## Application by Four Ashes Limited for an Order Granting Development Consent for the West Midlands Interchange

### The Examining Authority's written questions and requests for information (ExQ1)

Issued on 4 March 2019

Figure 12.6 **A**

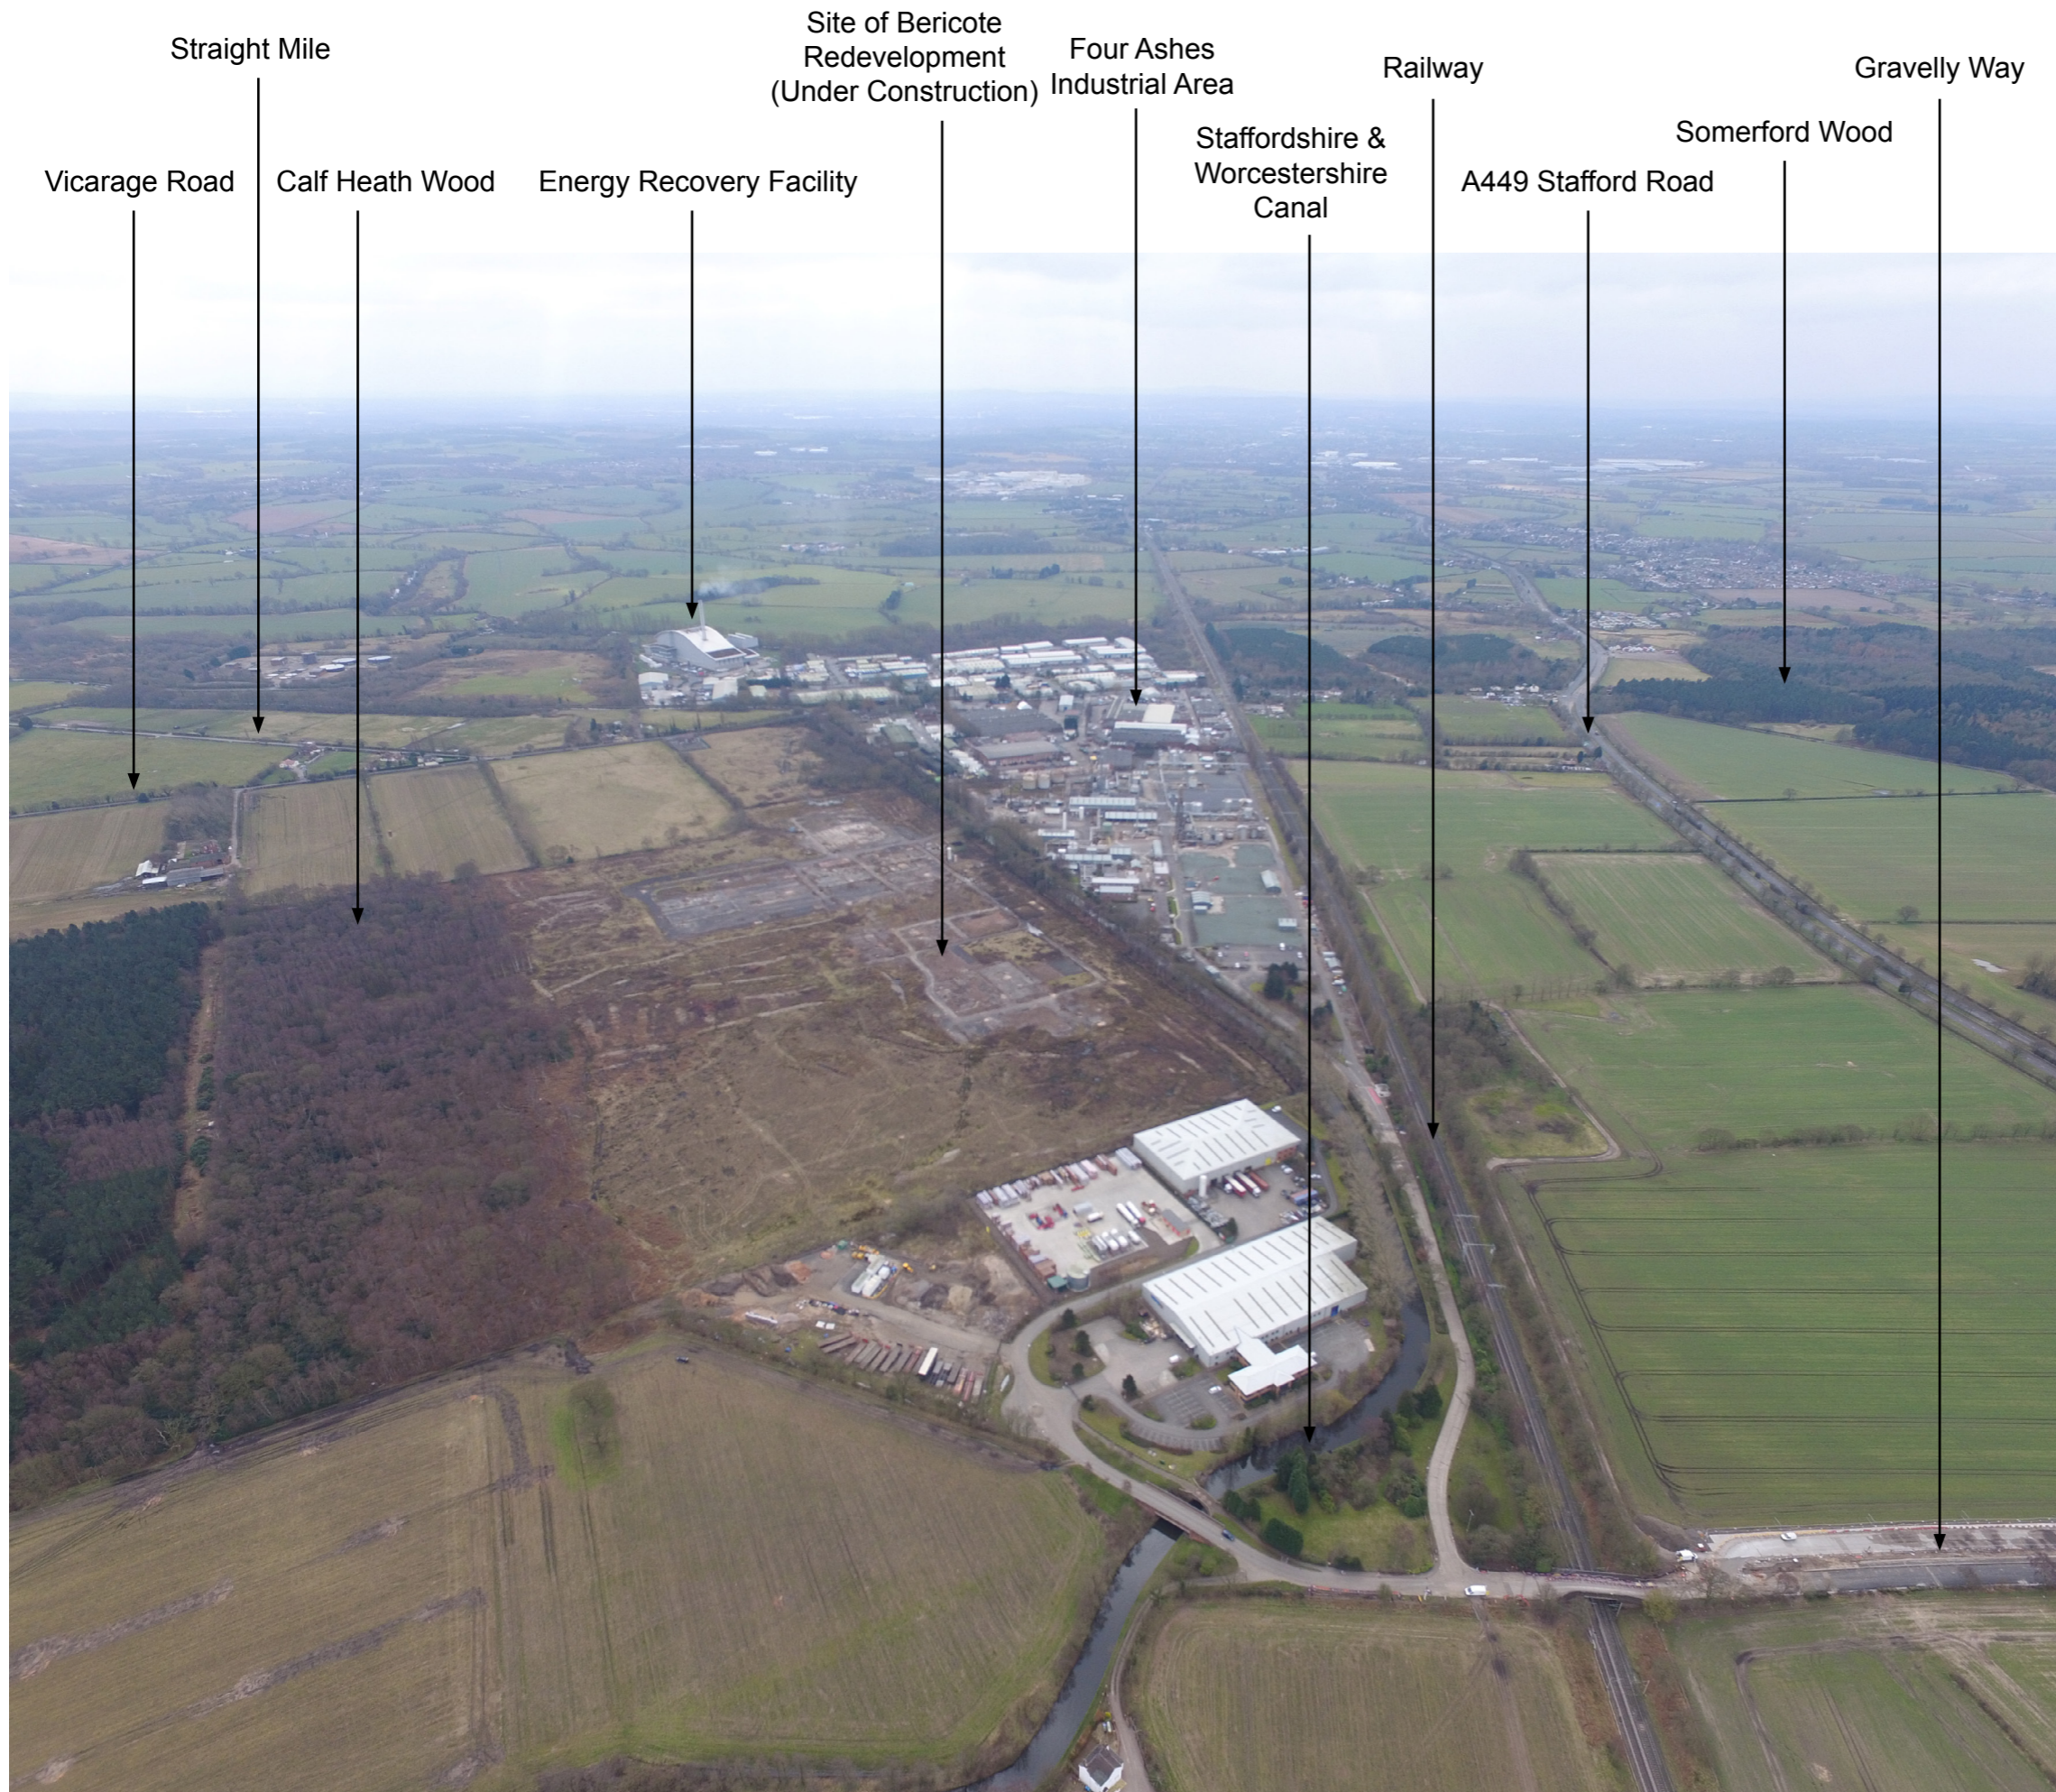
| ExQ1  | Question to:                             | Question:  |
|-------|--|--|
| 1.0.1 | The Applicant and SSDC                   | <p><b>Existing Land Uses.</b><br/>                     Some of the base plans used in the submission include the notation '<i>Caravan Park</i>' on land to the west of Croft Lane. This use is not evident on the aerial photographs in ES Figure 12.6 and does not appear to have been referenced or considered in the ES.</p> <p>(i) Does the use still exist and, if so, does it include any permanent residential use?<br/>                     (ii) If not, is there a planning permission in place or other means by which such a use could be resumed or resurrected in this location and could this include any permanent residential use?</p> |
